LA COSECHA SNACKS
 161 S McKinley Street, Coats, NC 27521

NOTICE TO CONTRACTOR
 All construction must comply with current NC Building Codes and is subject to field inspection and verification.
 Reviewed for Code Compliance
 06/15/2026

LA COSECHA SNACKS

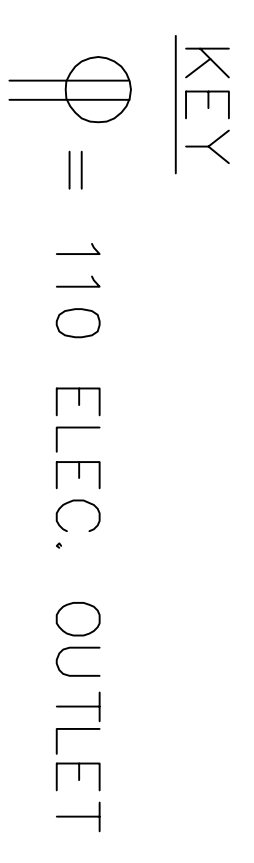
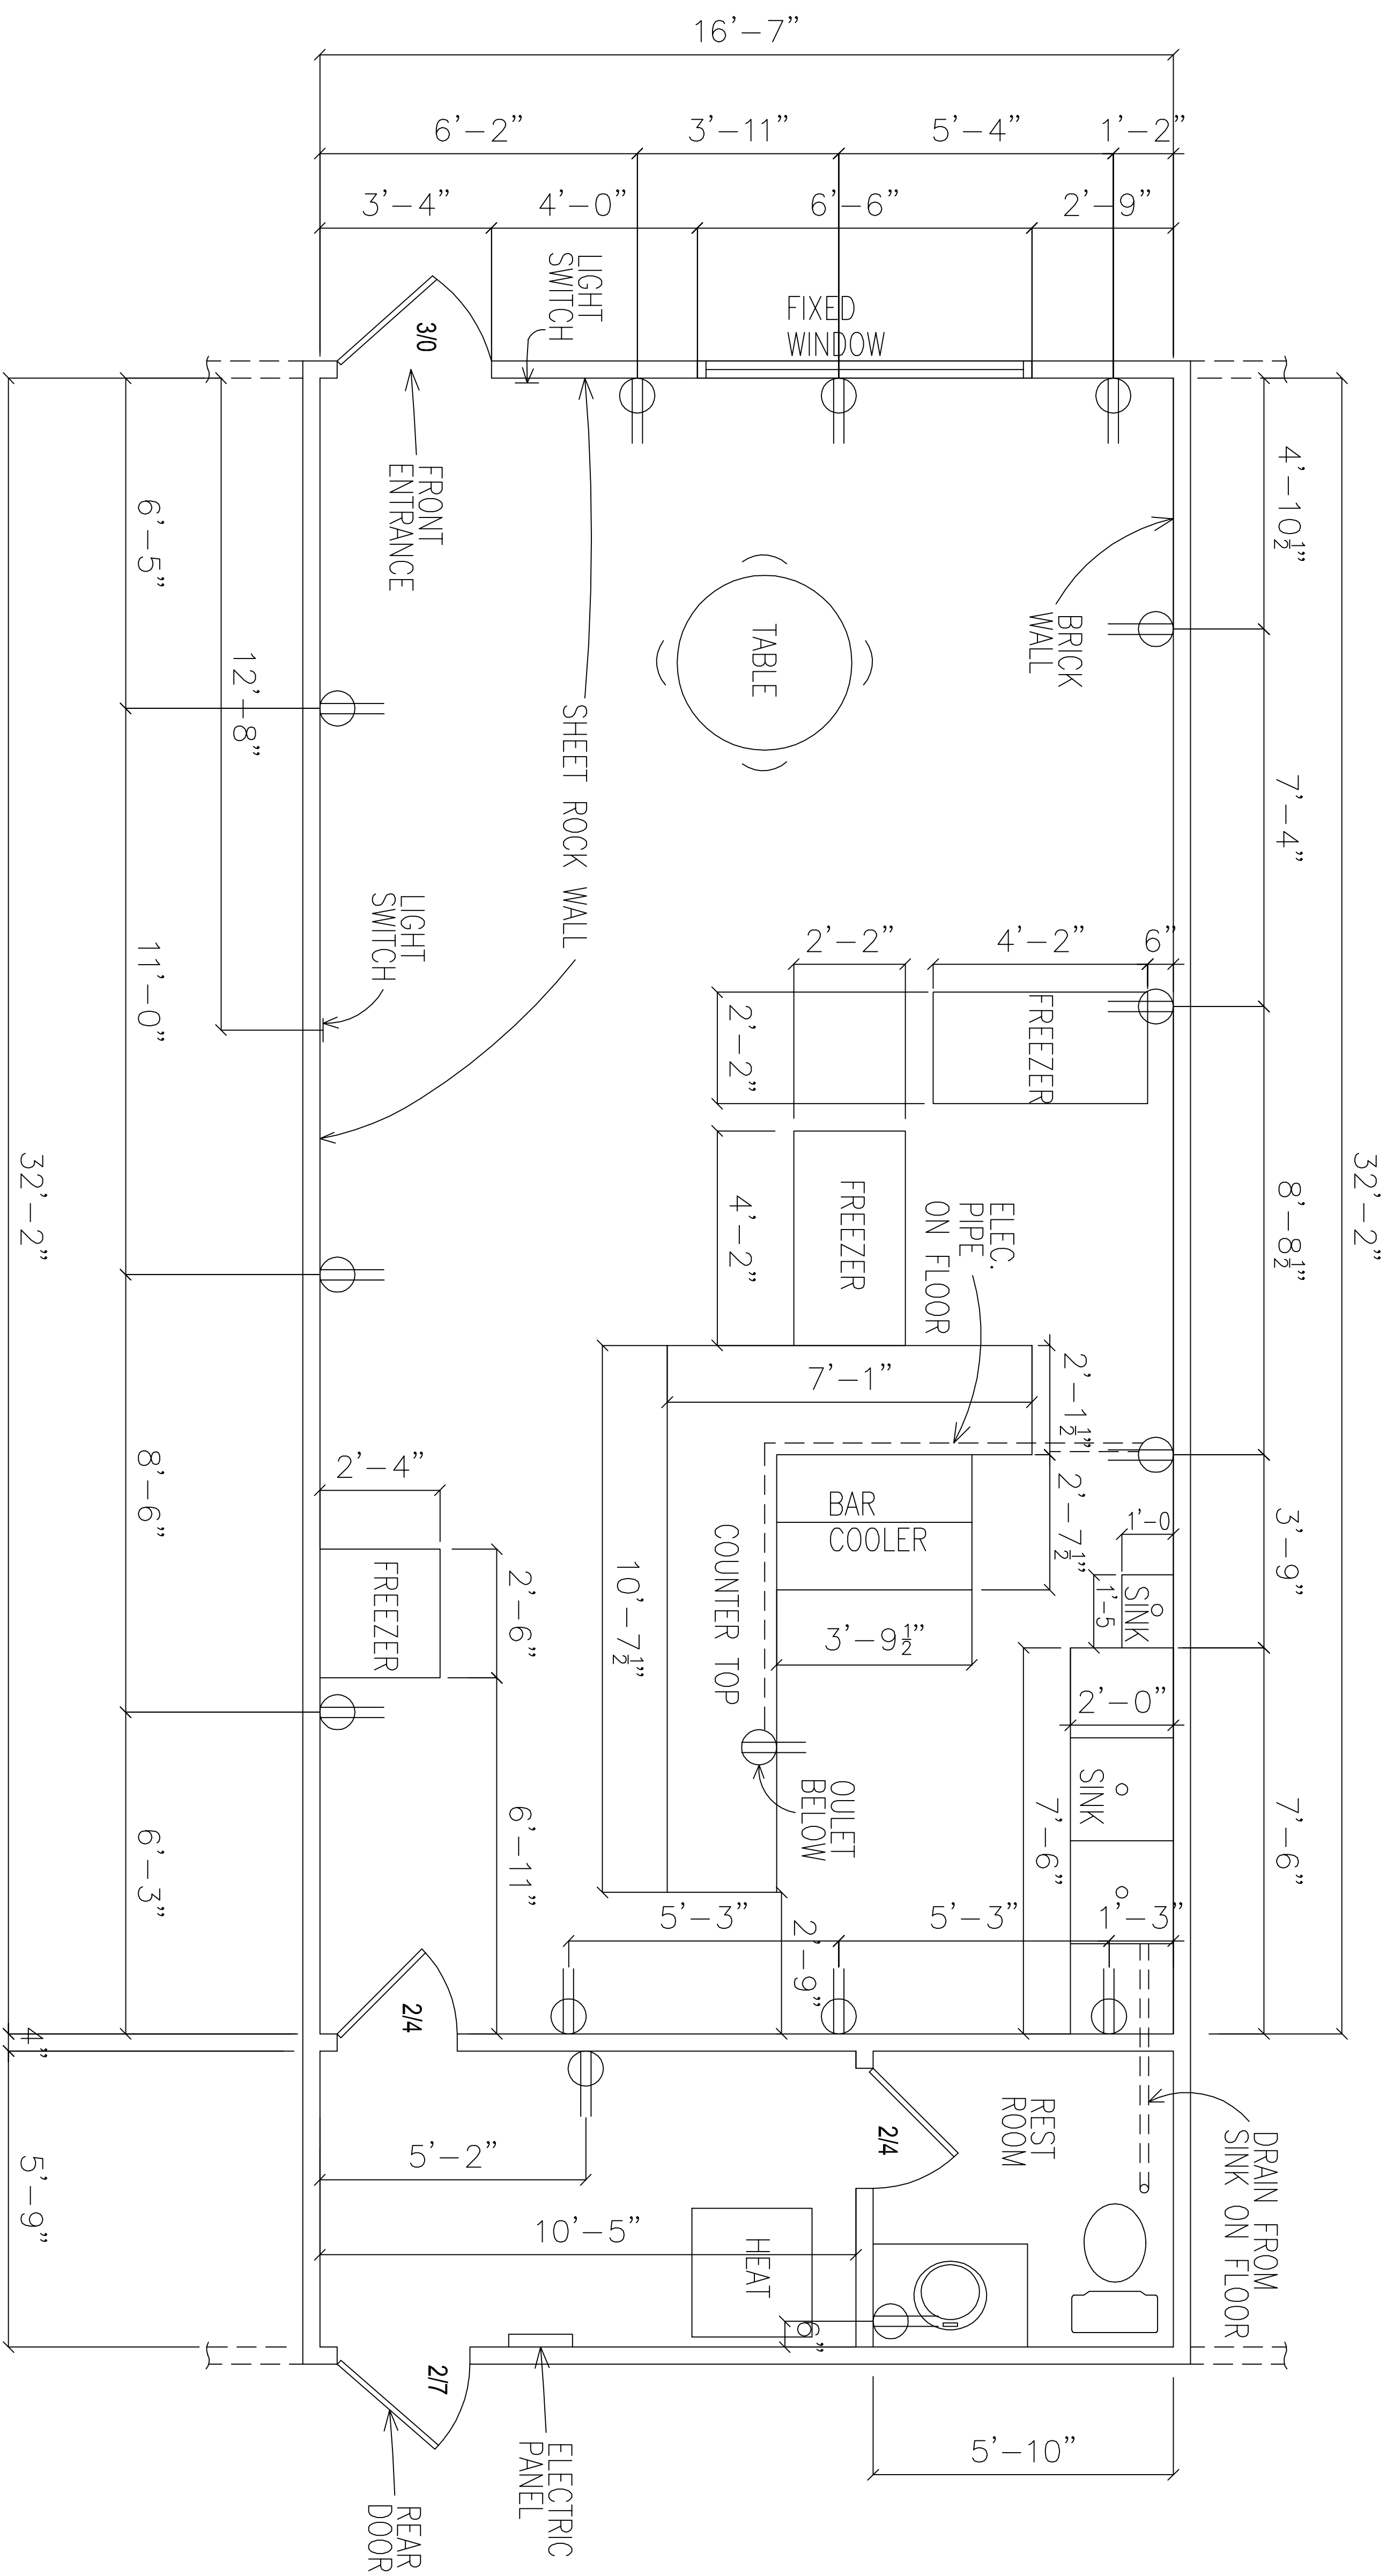
RMC only allowed

May not encroach on turning radius
